**Planning Department  
Transportation Development Services**

May 29, 2015

**Re: IL Vicino Canteen Brewhouse Kitchen Expansion**  
**2381 Aztec Rd NE**  
**Traffic Circulation Layout**  
Engineer's/Architect's Stamp dated 5-11-15 (G16-D089)

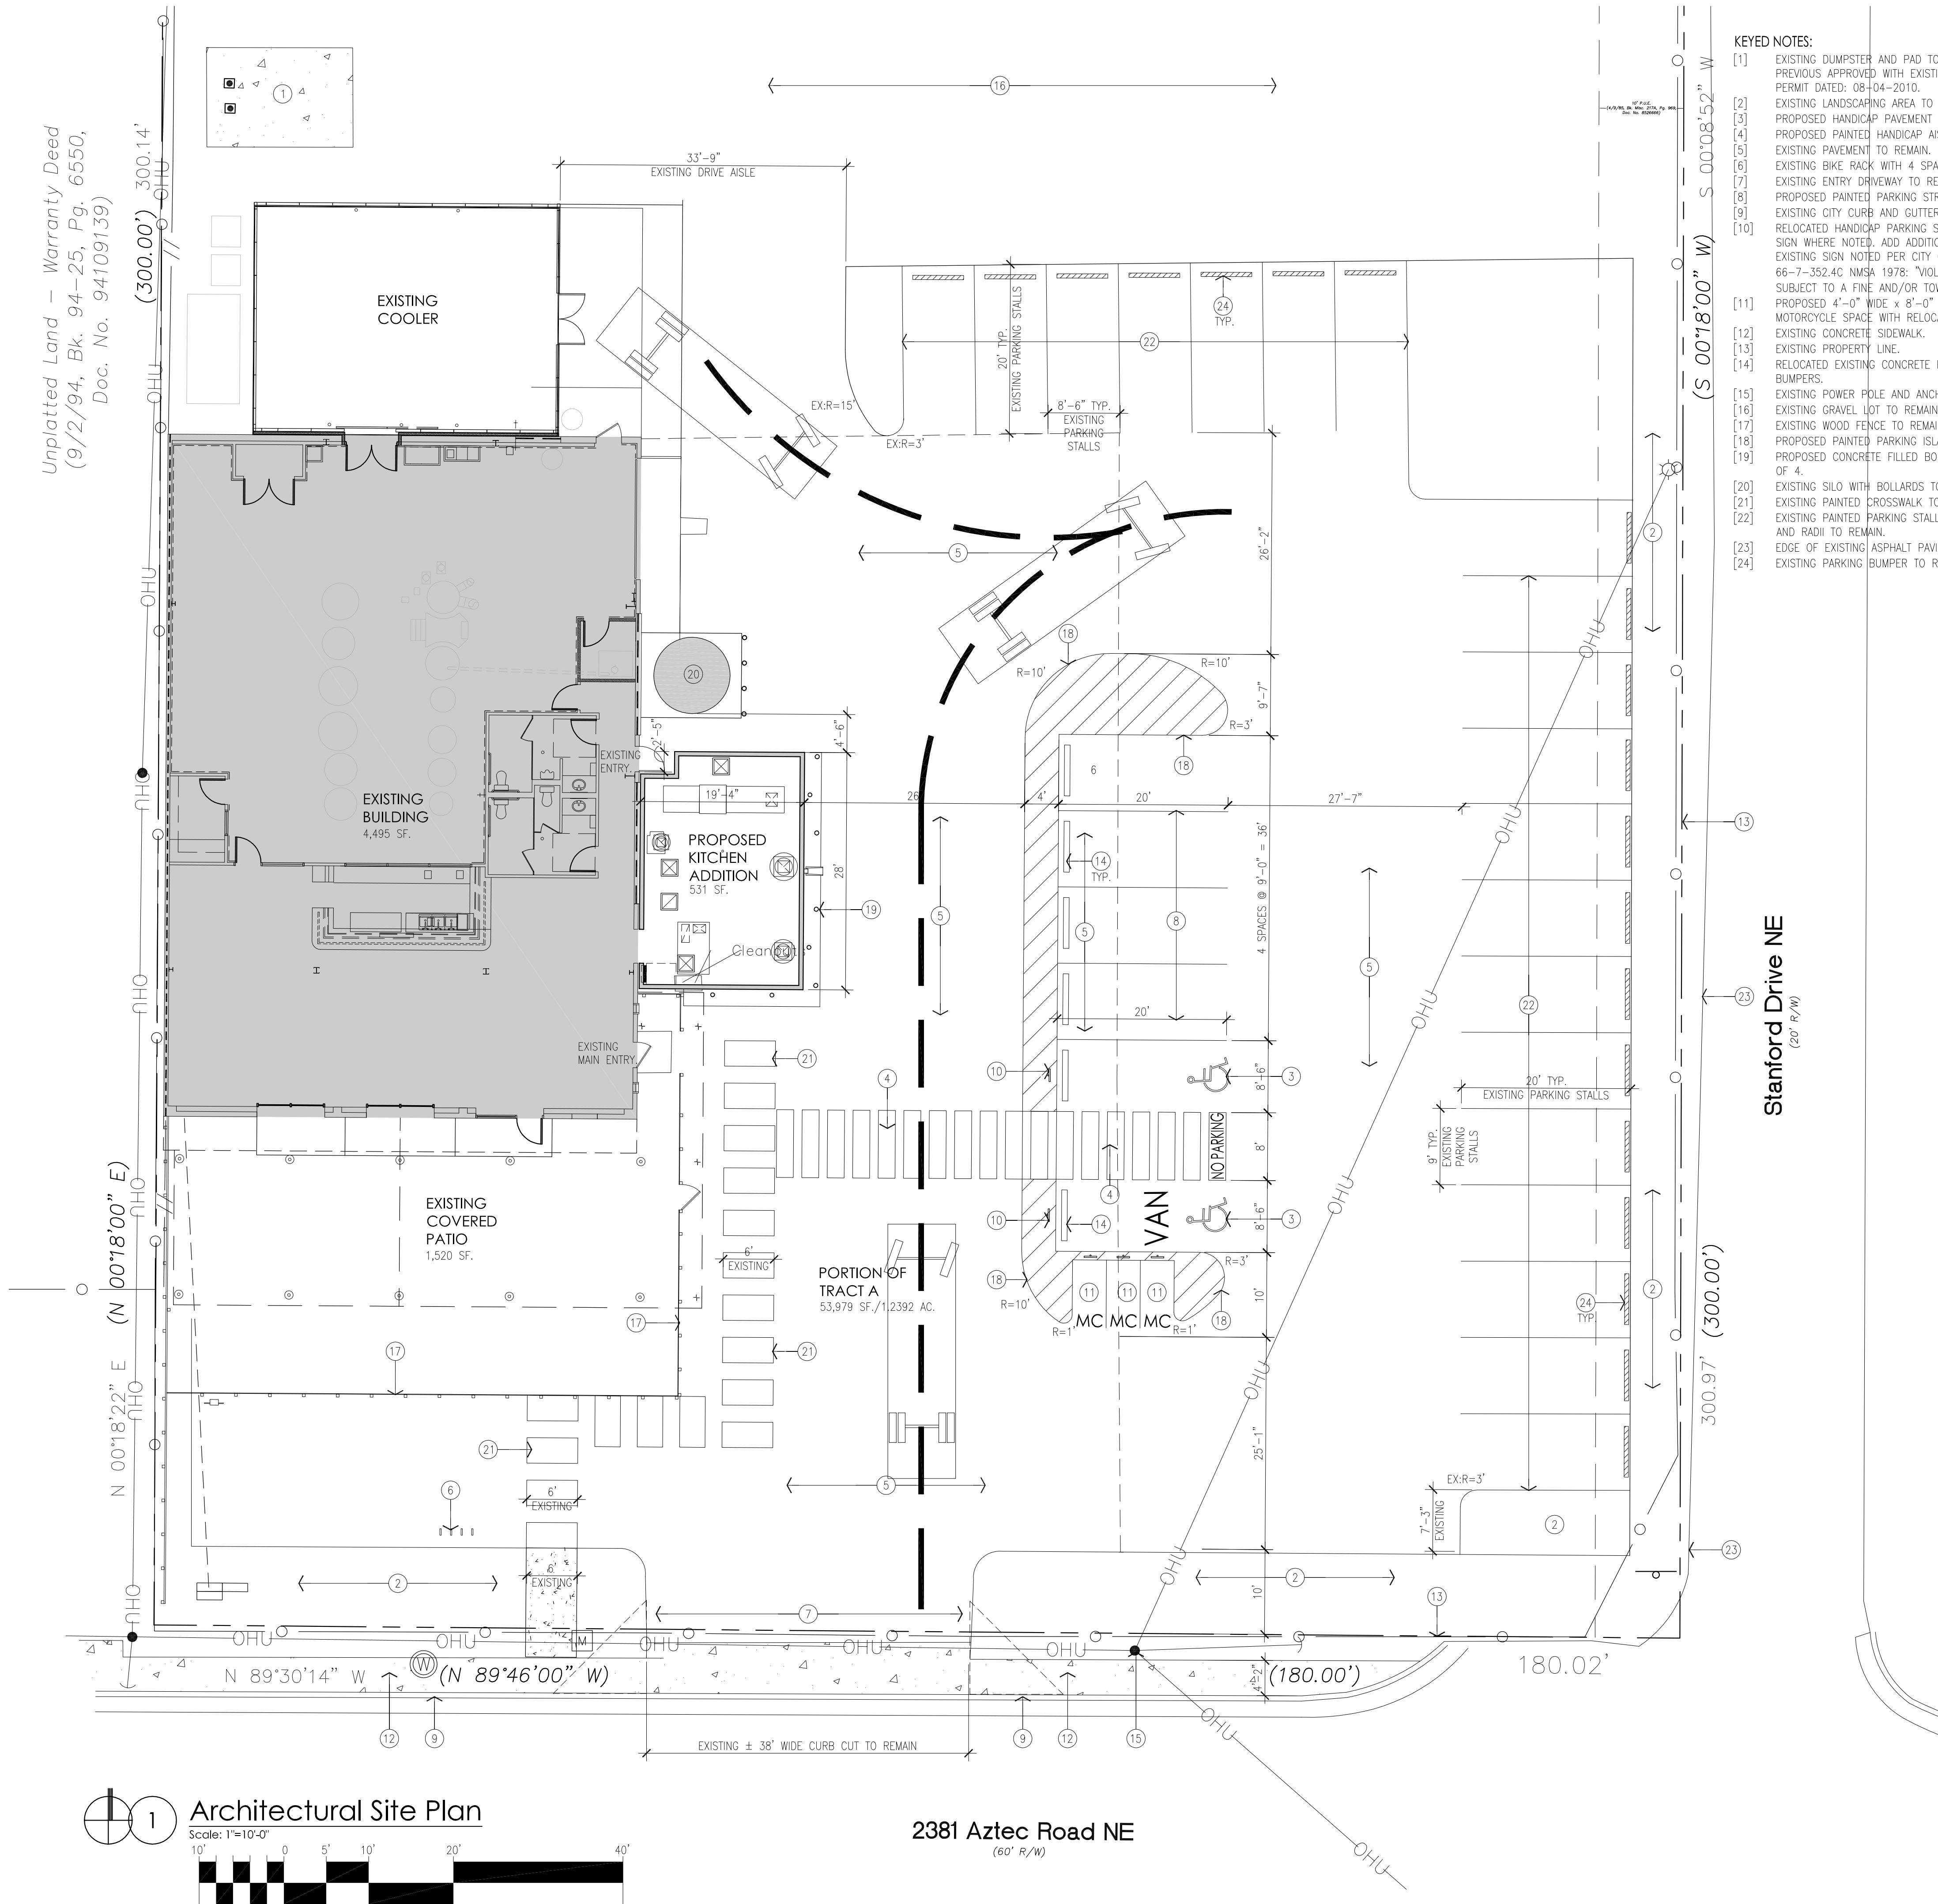
1. Please identify and dimension all existing pedestrian walkways from the public R.O.W. and from the existing parking lot. Dimension the width of the public R.O.W. sidewalk.

2. Please identify and dimension lot and all existing parking spaces in the "Additional Parking Area".
3. Please clearly dimension the drive aisle between the proposed kitchen addition and the handicap parking area. Per the DPM, the drive aisle must be a minimum of 24 ft. wide.

4. The ADA van accessible sign must have the required language per 66-7-352.4C NMSA 1978 **"Violators Are Subject to a Fine and/or Towing."** Please provide a detail of this sign. Please provide detail on drawing. Please ensure that these signs are placed in the proposed painted parking island.

5. Per the DPM, a 6 ft. wide ADA accessible pedestrian pathway is required from the public sidewalk to the building entrances. Please clearly show and dimension this pathway Note 21.

6. Per the DPM, a 6 ft. wide ADA accessible pedestrian pathway is required from the HC parking stall access aisles to the building entrances. Please label and dimension pathway Note 3.

7. Provide a min 6" or max 8" high concrete barrier curb or other acceptable barrier between landscaping and parking areas and/or drive aisles. Provide parking bumpers west of handicap parking spaces along the driving isle to

provide protection for the handicap signage. Please provide parking lot details of the "Additional Parking Area".

8. Design delivery vehicle route needs to be shown.
9. Service vehicle and/or refuse vehicle maneuvering must be contained on-site; provide a copy of refuse approval (if applicable).
10. Please provide a sight distance exhibit for the entrance on Aztec Rd. (see the *Development Process Manual, Chapter 23, Section 3, Part D.5 Intersection Sight Distance*).

11. Please add the following note to the clear sight triangle: "Landscaping and signage will not interfere with clear sight requirements. Therefore, signs, walls, trees, and shrubbery between 3 and 8 feet tall (as measured from the gutter pan) will not be acceptable in this area."
12. Please specify the City Standard Drawing Number when applicable.
13. Please include two copies of the traffic circulation layout at the next submittal.
